Attachment A

Response to Request for Additional Information

13 November 2020

Project	Hills Showground Station Precinct
Drawing Title	Building Heights Plan
Scale	1:2000 @A3

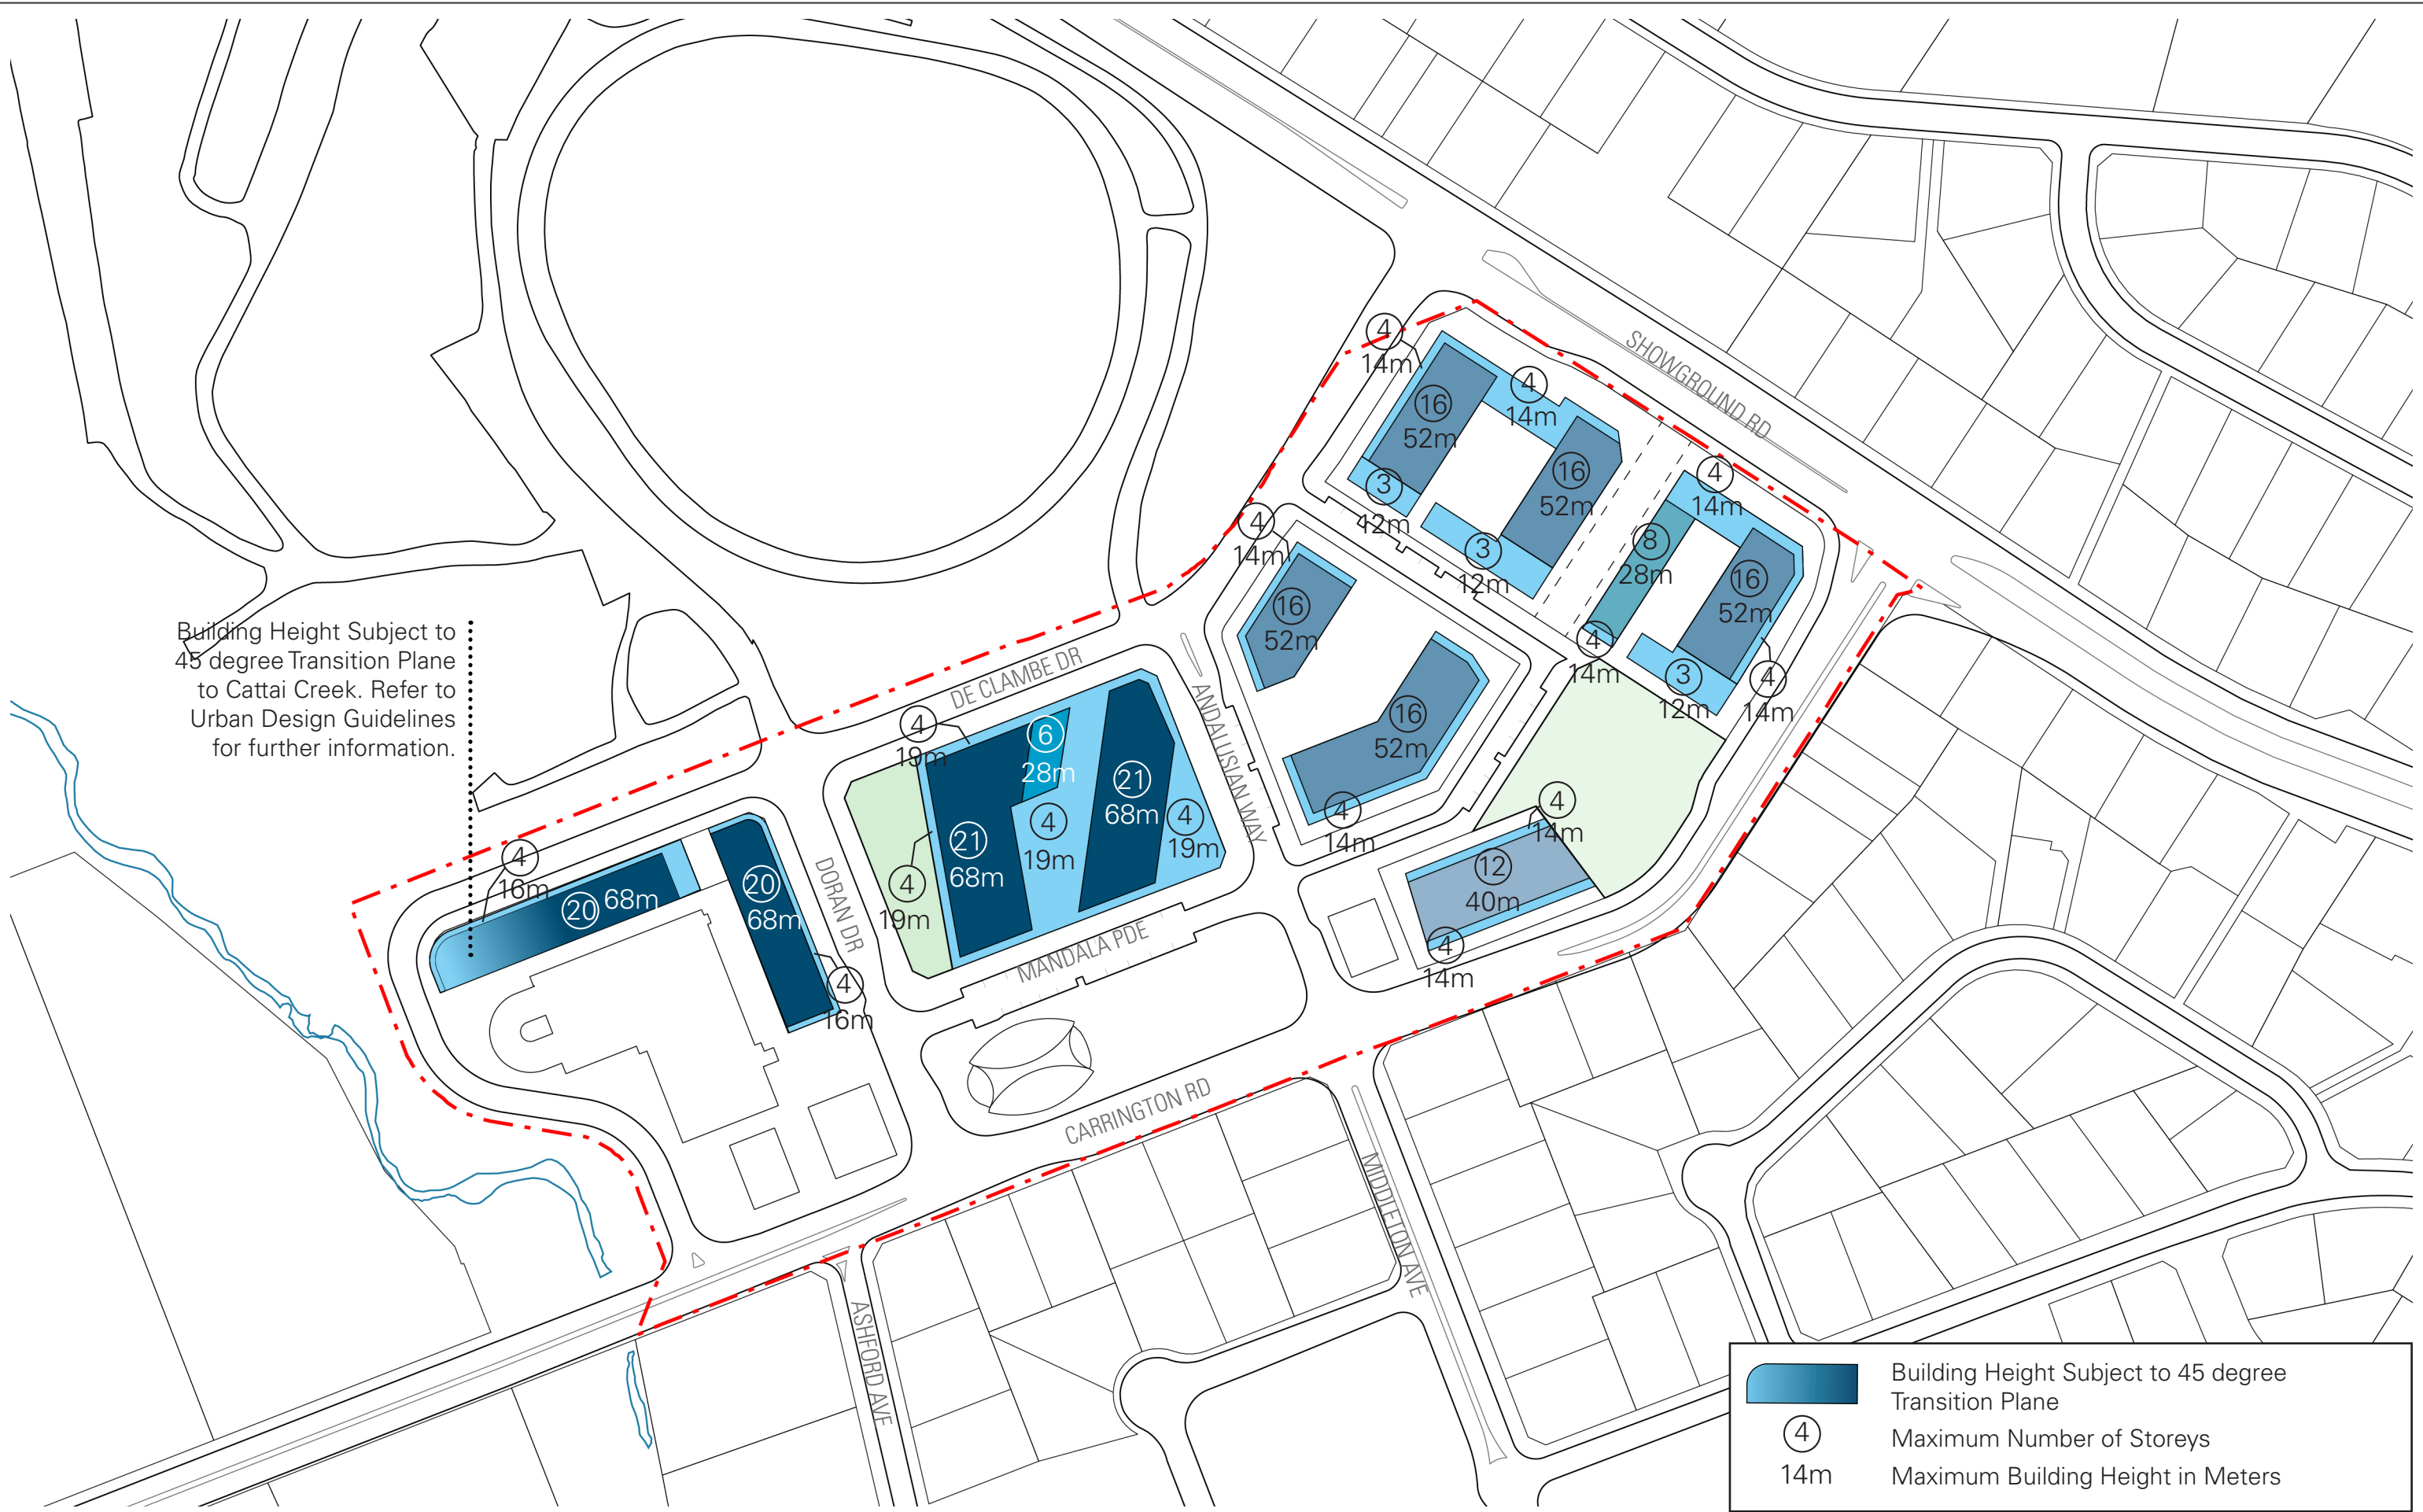
Other	(i) Amend the Building Heights Plan to include both height in storeys and metres to be	The Building Heights Plan has been amended to include the maximum height in both storeys and metres.	Annexure B - Urban Design response to RFI - page 15

Item	Request for additional Information	Project Response	Annexure Reference
	consistent with the proposed Design Guidelines.	 <p><i>Figure 4: Drawing Set Building Heights Plan Original vs Amended Comparison (COX Architecture, 2020)</i></p>	Annexure C – Drawing Set for Approval – page 18
	(ii) Clarify how the additional community facilities contribution identified in the Social Infrastructure Report will be secured and the timing of the contribution.	<p><u>Timing/ when will the community use be required?</u></p> <p>The Social Infrastructure Assessment (SIA) identified the need for a combined community centre and library space (community facility) of around 500 square metres based on the Hills Showground Station Precinct proposed residential population of 3,570 people (or to the development potential of up to 1700 dwellings). The SIA applied the benchmark of 80 square metres per 1,000 people for community use and the NSW State Library Population Based Calculator for the library space.</p> <p><u>Which development does secured delivery apply to?</u></p> <p>The community facility shown in the concept proposal is in the Doran Drive Precinct as this will be the heart and central hub of the Hills Showground Station Precinct.</p>

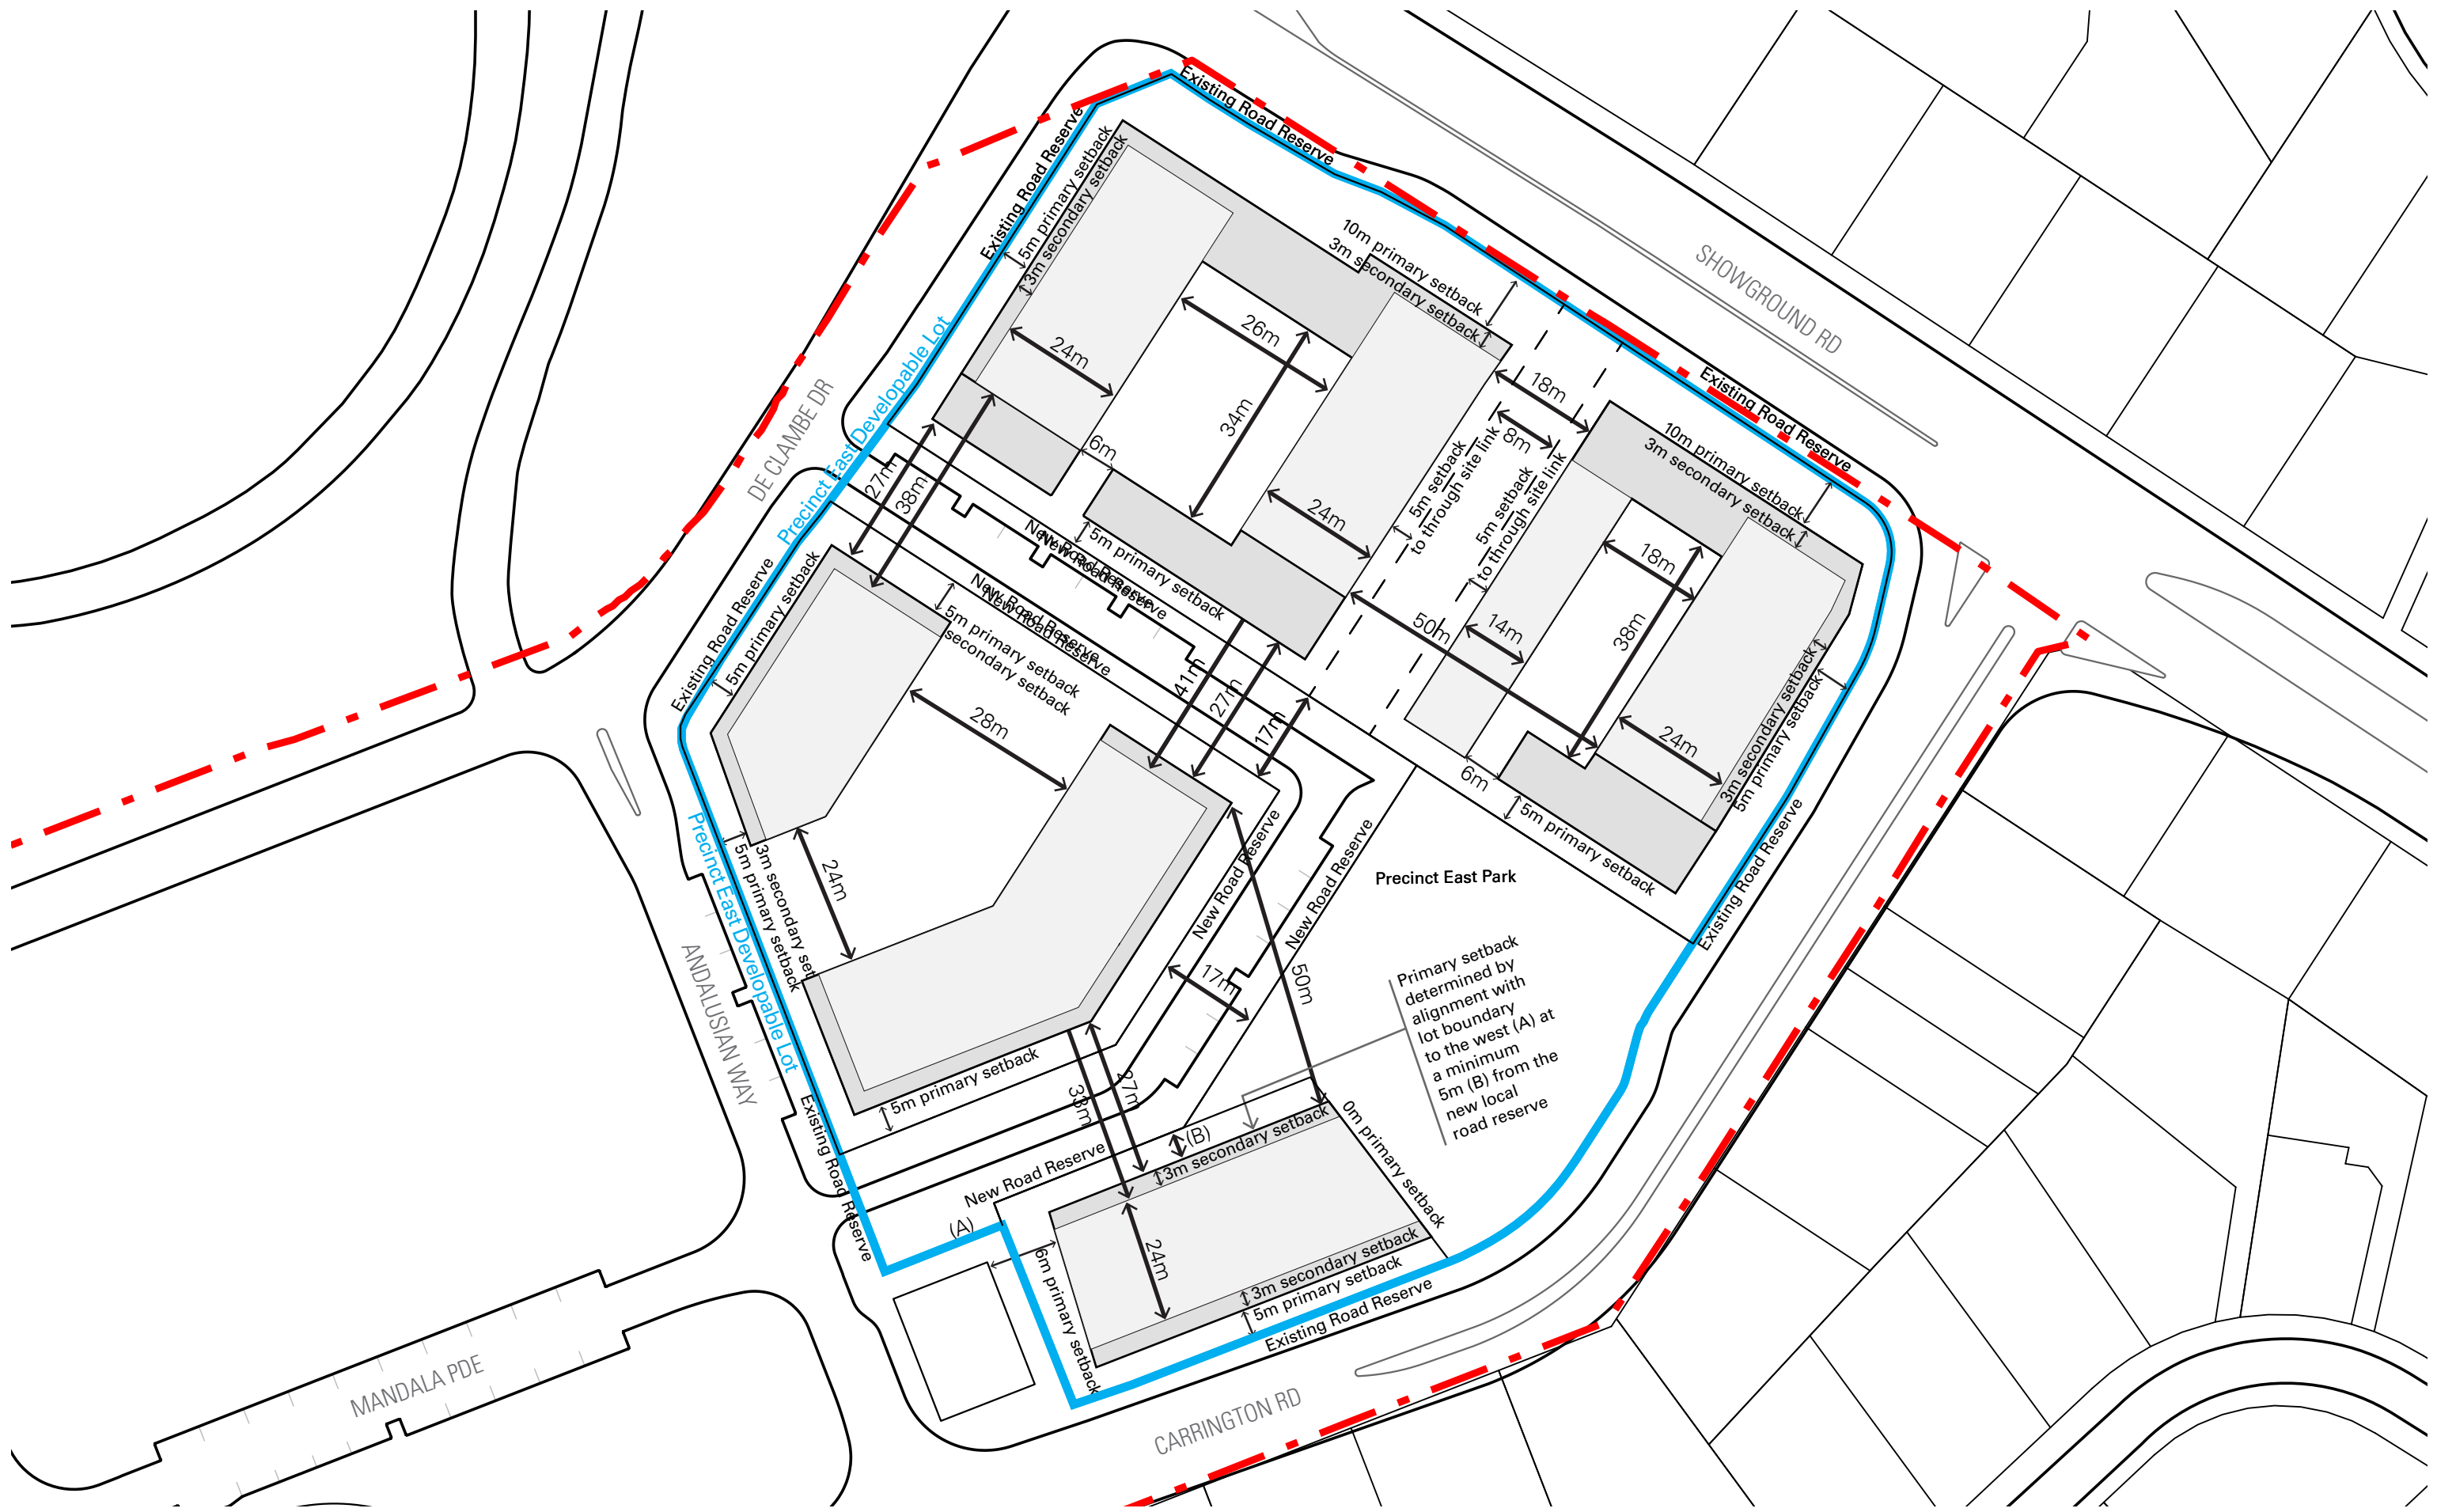
Item	Request for additional Information	Project Response	Annexure Reference
Built Form	<p>Further illustrate how future development within the proposed building envelopes would achieve satisfactory urban design outcomes and levels of amenity for the Doran Drive Precinct, particularly in respect to:</p> <p>(i) the interface between the 4-storey podium fronting Andalusian Way/Mandala Parade and the angled towers, Buildings G and F</p> <p>(ii) the transition from a 2 storey to a 4-storey podium along Doran Drive to Andalusian Way.</p> <p>Demonstrate the building separation distance between the proposed townhouses fronting Andalusian Way and Buildings P & R in Precinct East are sufficient to support good levels of residential amenity.</p>	<p>The future development in the Doran Drive Precinct would satisfactorily achieve good urban design and place outcomes with good levels of amenity.</p> <p>(i) The interface between the 4-storey podium fronting Andalusian Way/Mandala Parade and the above angled towers, Buildings G and F is a key focal point and contributor to the experience of the streetscape along Mandala Parade and arrival into the precinct from the Hills Showground station. Ensuring high levels of amenity on Mandala Parade and the surrounding public domain of the Station Plaza and Doran Drive Plaza has been the primary determinant in the provision of the podium heights and the angle of the building envelopes for the towers above the podium. The building envelopes for Buildings G and F ensure that:</p> <ul style="list-style-type: none"> The minimum proportions of the public spaces that are to achieve a minimum of 2 hours of sunlight between 9am and 3pm at the winter solstice (21 June), most notably, Doran Drive Plaza 100%, Station Forecourt 80%, and the Station Plaza 65%. Views to the sky to the north are afforded from the station forecourt and from the public domain along Mandala Parade. That the above podium interface to Mandala Parade is visually exciting and that the shorter length of building envelopes is what defines the interface above the podium. <p>The Urban Design Guidelines (UDG) prescribe a number of conditions to resolve the interface between Buildings G and F and ensures that the principles and objectives of the Mandala Parade and Andalusian Way are achieved. The relationship between the towers podium and public domain is managed through:</p> <ul style="list-style-type: none"> Aligning vertical façade elements from the podium to the tower above, drawing the edge of towers down to and through the podium and using it to define material changes in the podium and/or where building entries can be located. The podium is a constant for the length of the interface with the tower above, ensuring consistency across the broader precinct where a 2-4 storey podium with setback tower above is being prescribed. 	<p>Annexure B – Urban Design response to RFI - pages 2 to 6</p> <p>Annexure C – Urban Design Guidelines – Section 4.2.11, Section 5.2.9 and Section 5.2.11</p>

Item	Request for additional Information	Project Response	Annexure Reference
	<p>The Applicant shall consider appropriate Design Guidelines to secure the desired urban design outcome with respect to point (i) and (ii) above.</p>	<ul style="list-style-type: none"> Providing for a number of central communal open space areas that open towards the Mandala Parade frontage to drive further interaction between the public and private domain and further passive surveillance of Mandala Parade and the station plaza. <p>Additional Design Guidance has been prepared for the Mandala Parade and Andalusian Way interfaces which demonstrates further how the objectives and controls of the UDG can be achieved. This additional design guidance for these two important interfaces are included in the revised Urban Design Guidelines under 4.2.11 – Street Interface.</p> <p>(ii) In reviewing the Urban Design Guidelines for Precinct East, we recommend that the 3m building separation between the townhouse apartments addressing the new local street and the new local park and apartment buildings P and R be removed.</p> <p>Instead, we propose to increase the building separation from 3m to 6m between the townhouse apartments and Buildings Q and M. This ensures that there is greater residential amenity for residents of the townhouse apartments, and other residents will benefit from a wider access way to the communal open space as well as any dwellings that are accessed from the communal open space.</p> <p>Connecting the townhouse apartments to Buildings P and R via a party wall for the first 3 storeys:</p> <ul style="list-style-type: none"> delivers housing choice and diversity of built form within Precinct East maintains ADG compliance for cross-ventilation and solar access with townhouses ventilated via a rooftop terrace maintains ADG compliance for the adjacent apartments within Buildings Q and M does not result in any additional GFA, or dwelling yield does not impede the ability for the development lots to achieve deep soil requirements <p>Additional design guidance has been prepared that demonstrates how floorplans for both the townhouse apartments and the adjoining apartments can satisfy the objectives and controls of the UDG and the solar access and cross ventilation requirements of the ADG.</p>
